27 April 2012

Our Ref: NW/RV/2012/28259/S

Application Number: 3/2012/0277
Site Address: Chatburn Road Clitheroe BB7 2BA
Proposal: Proposed erection of a new sports hall and re-orientation of existing tennis courts.

Proposed Ground Floor Plan 1:100

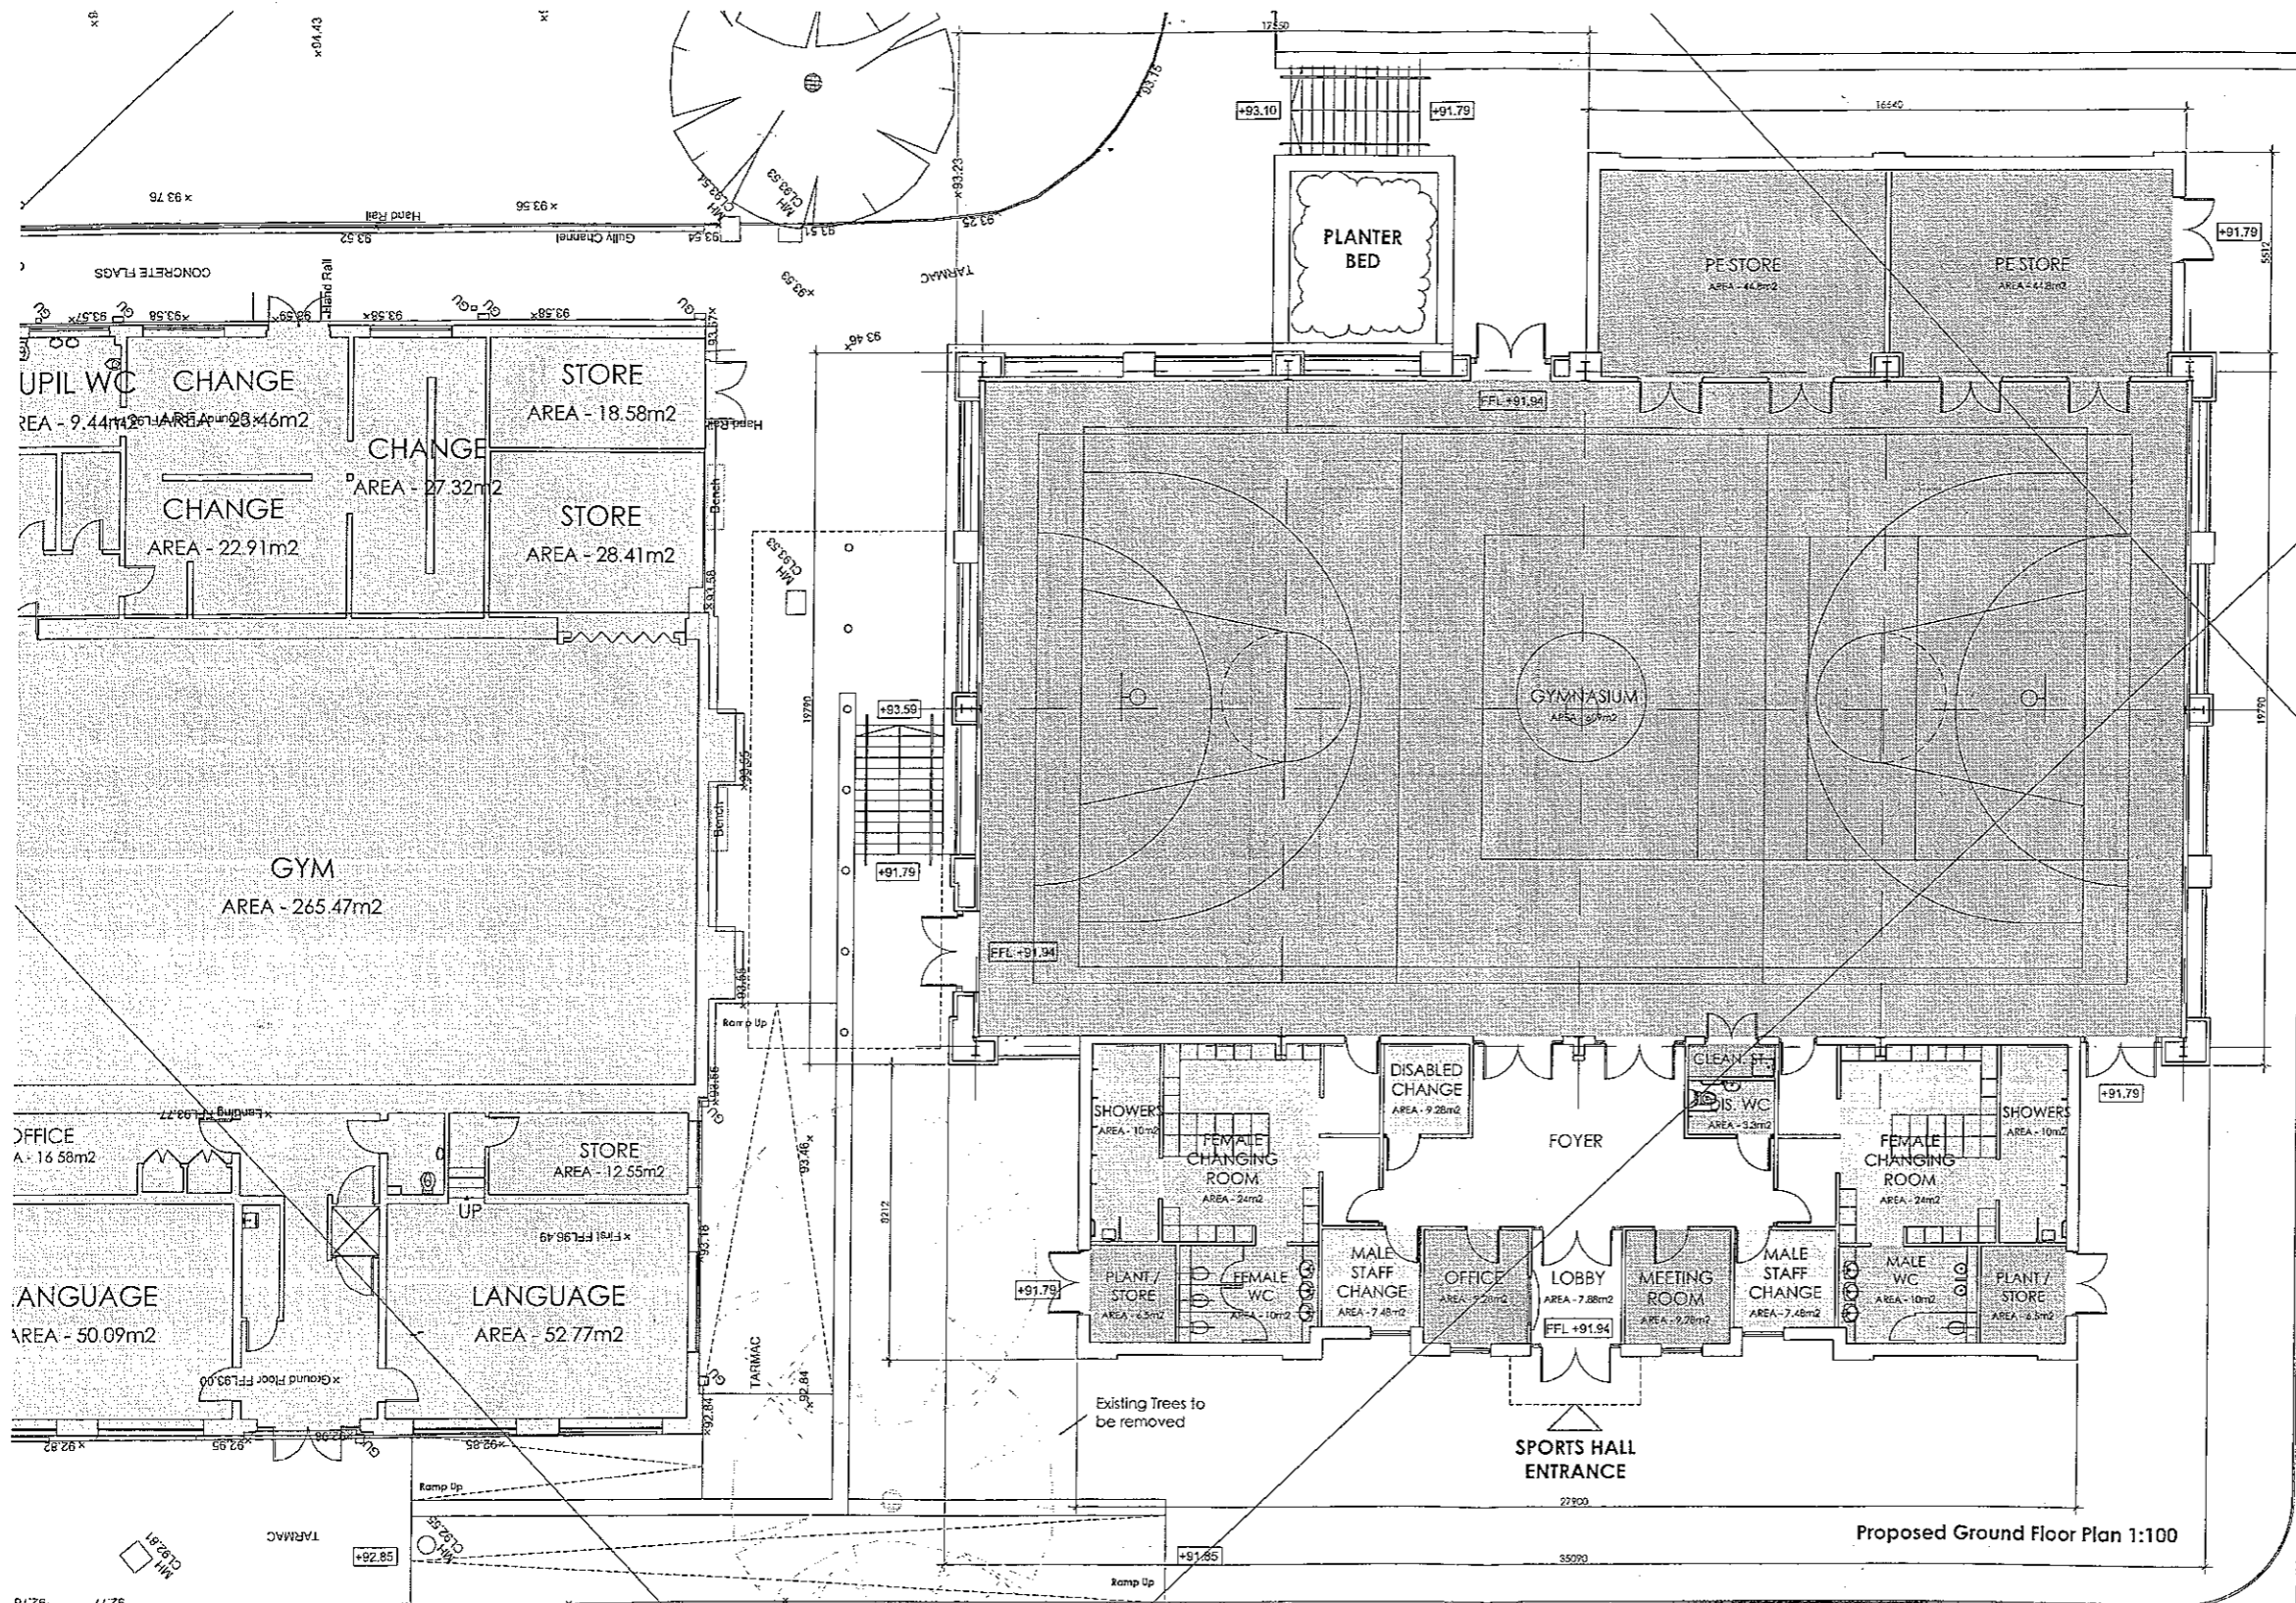
The poor quality of the plans on the website means I have not been able to scale from the drawings to ensure the sports hall and changing rooms meet the minimum design standards. Although I have noted there are doors opening into the sports hall area which is a safety hazard. The walls and doors of the sports hall act as a functional part of the sports hall, acting as rebound boards for some sports, and to have doors opening into the court area would be dangerous to hall users. I have provided a link to the design guidance on Sport England's website which I would appreciate being forwarded to the applicant for information. The guidance includes sports halls and accessible sports facilities to ensure they are DDA compliant.

Drawing Title
Proposed Site Plan

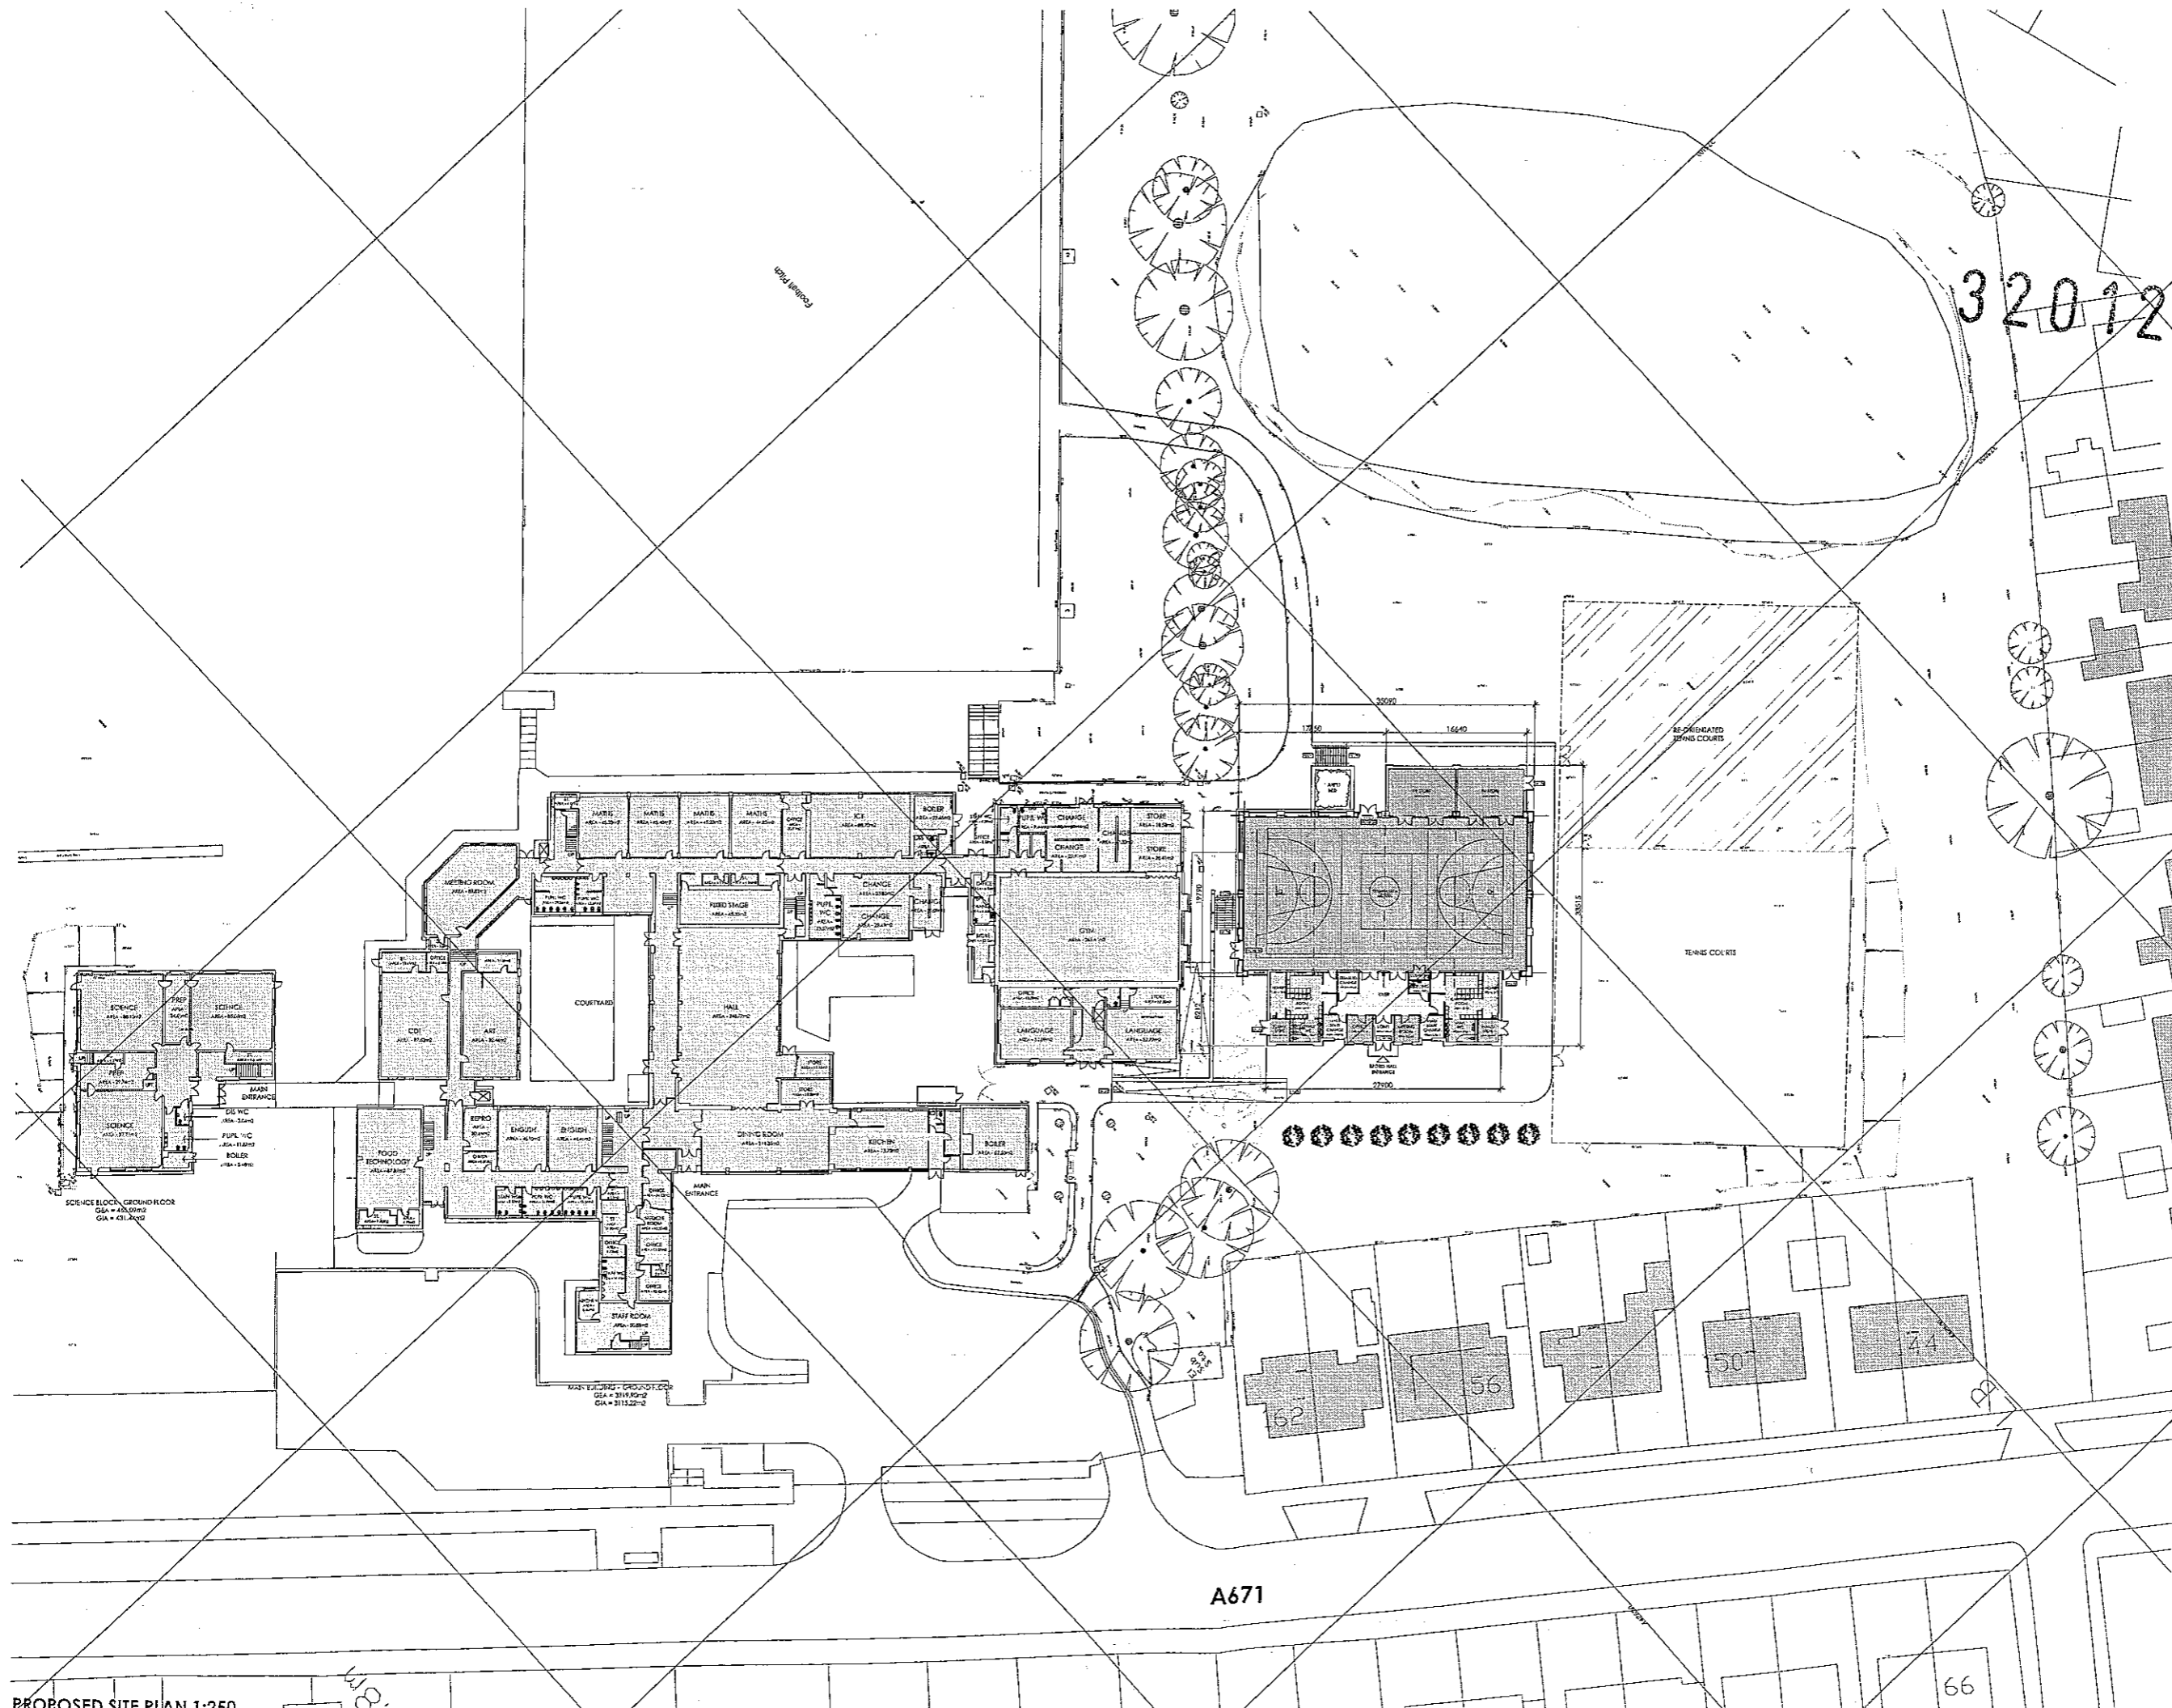
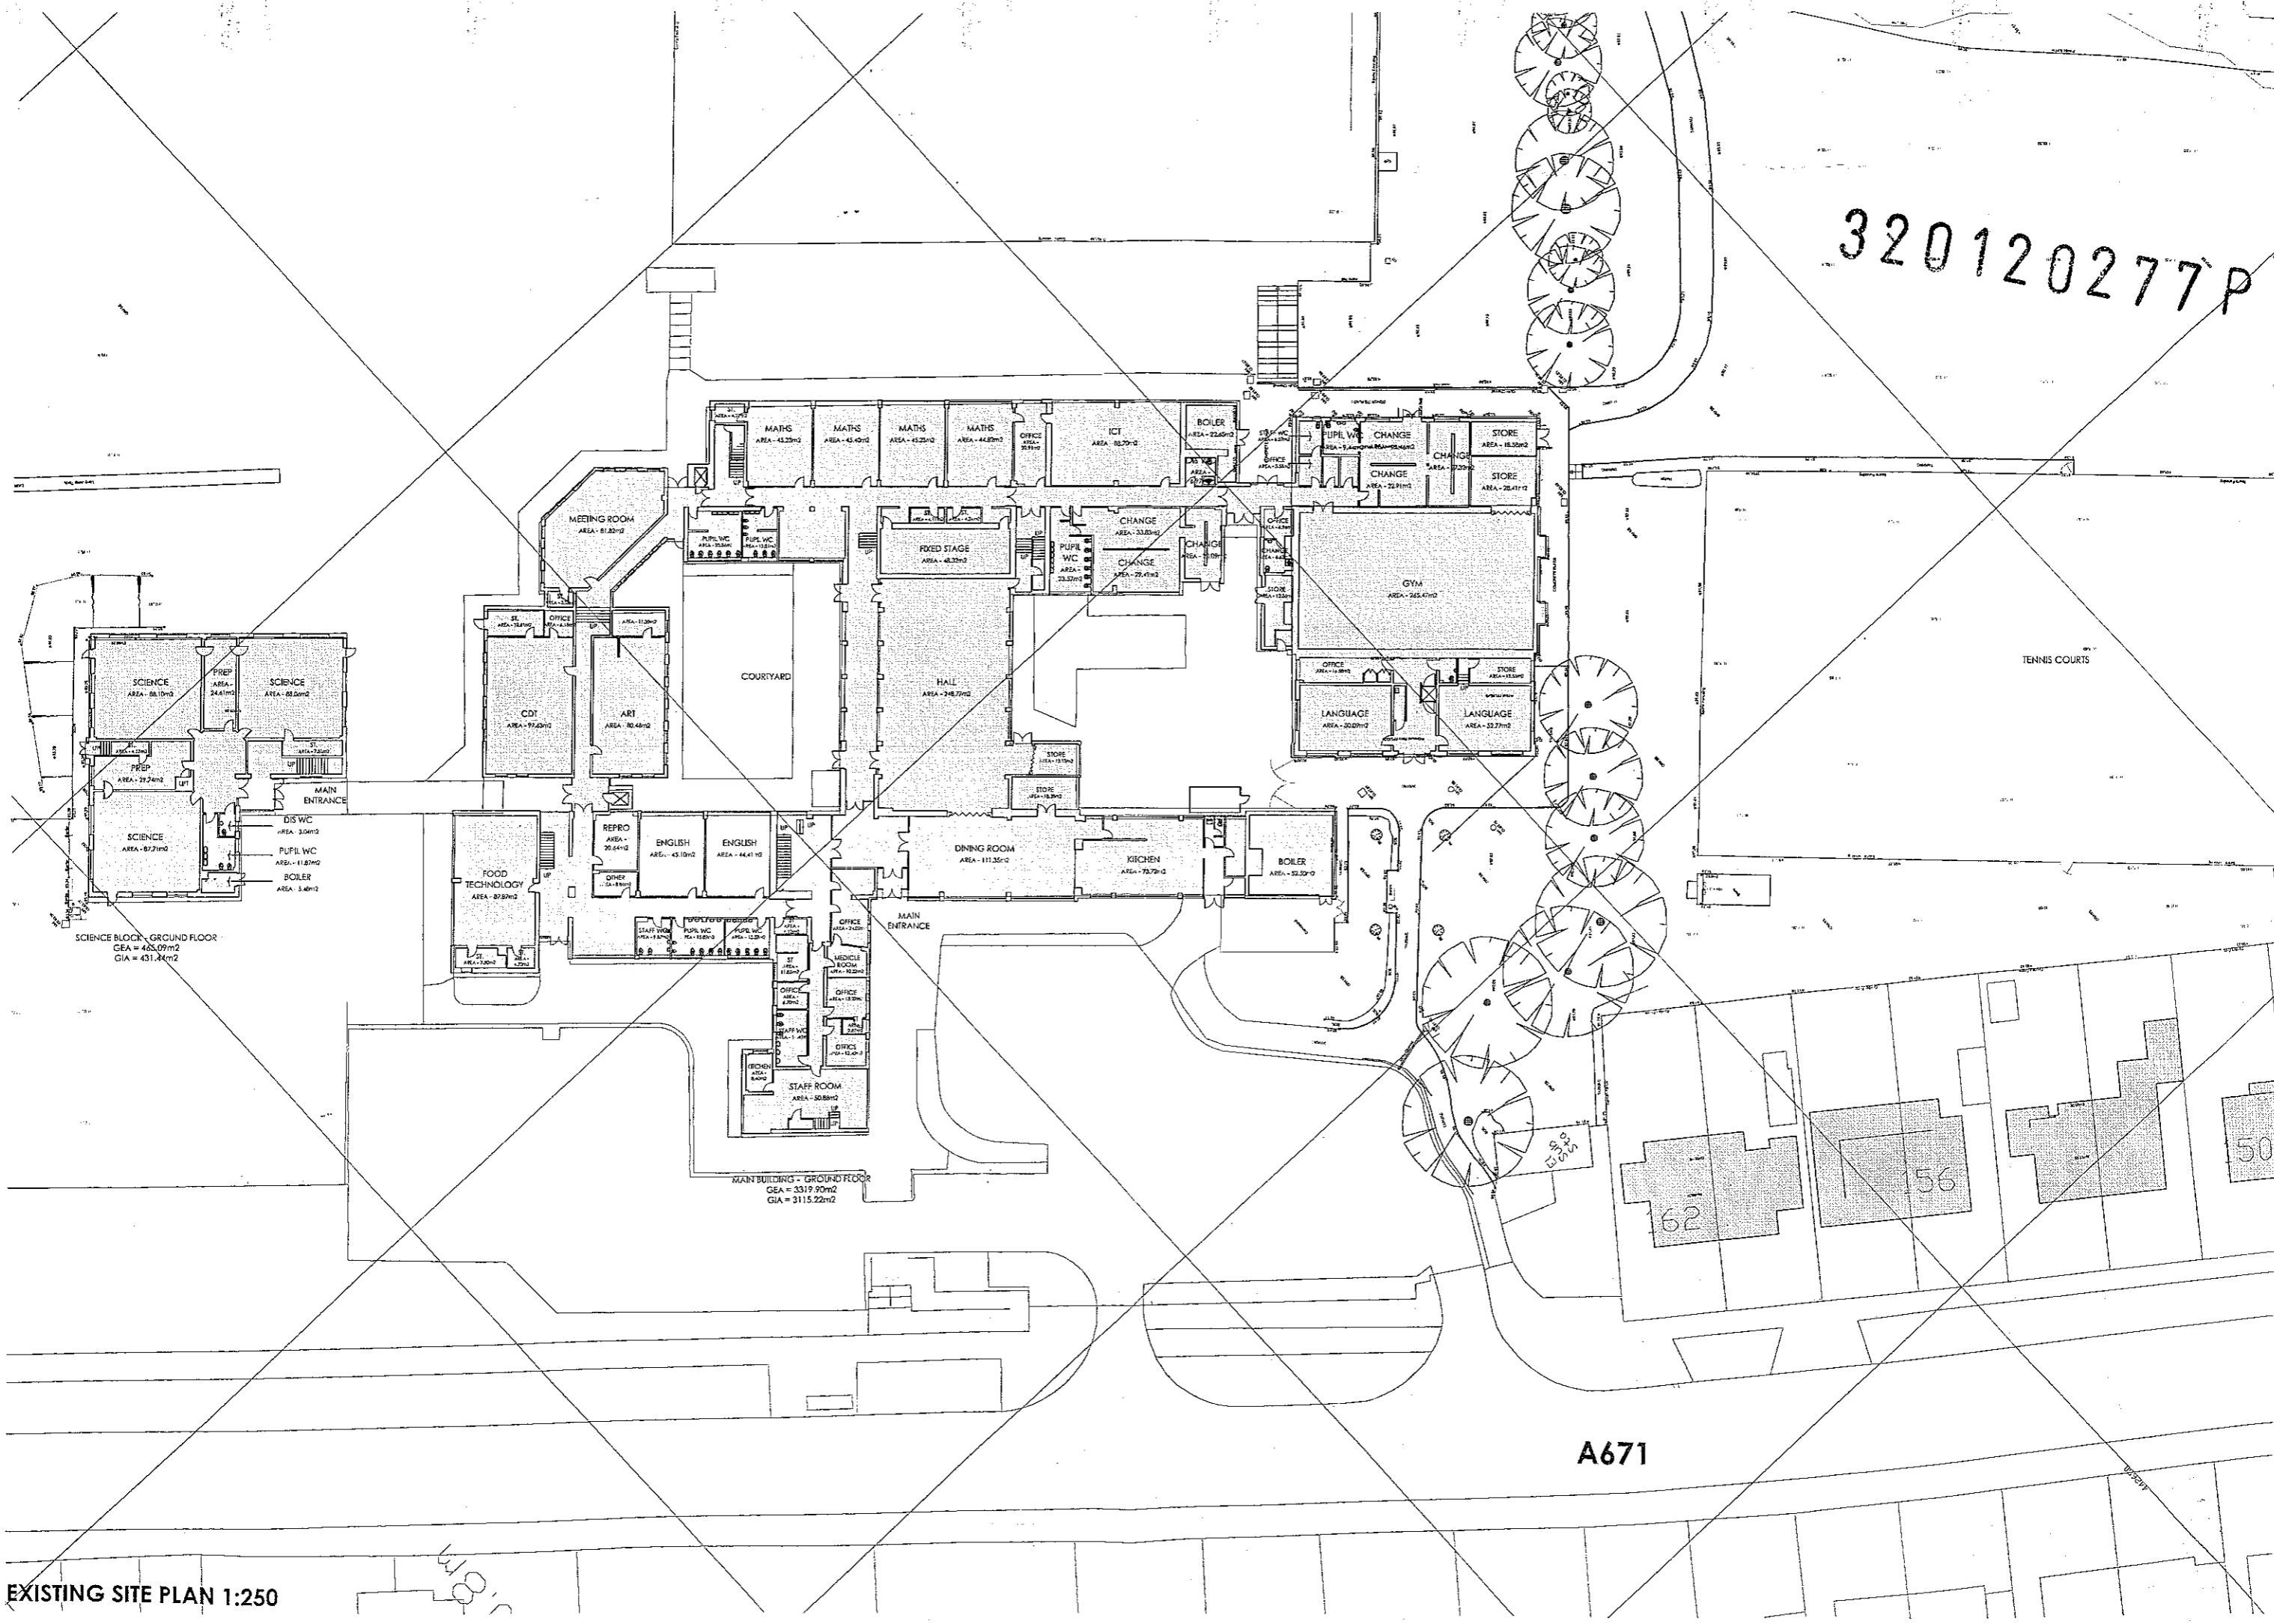
The proposal is to locate a new sports hall on the location of existing tennis courts, four in total. The tennis courts will be relocated and positioned north of the sports hall in an area that is currently amenity grassland. There are no plans showing the layout of the tennis courts and I have assumed 4 courts will be replaced as the Design and Access Statement infers this is the case.

As there are no plans showing the design and layout of the relocated tennis courts I have provided a link to the Lawn Tennis Associations Facility Design Guidance which I hope the applicant will find useful:
<http://www.lta.org.uk/clubs-schools/Resources---facility-guidance/>
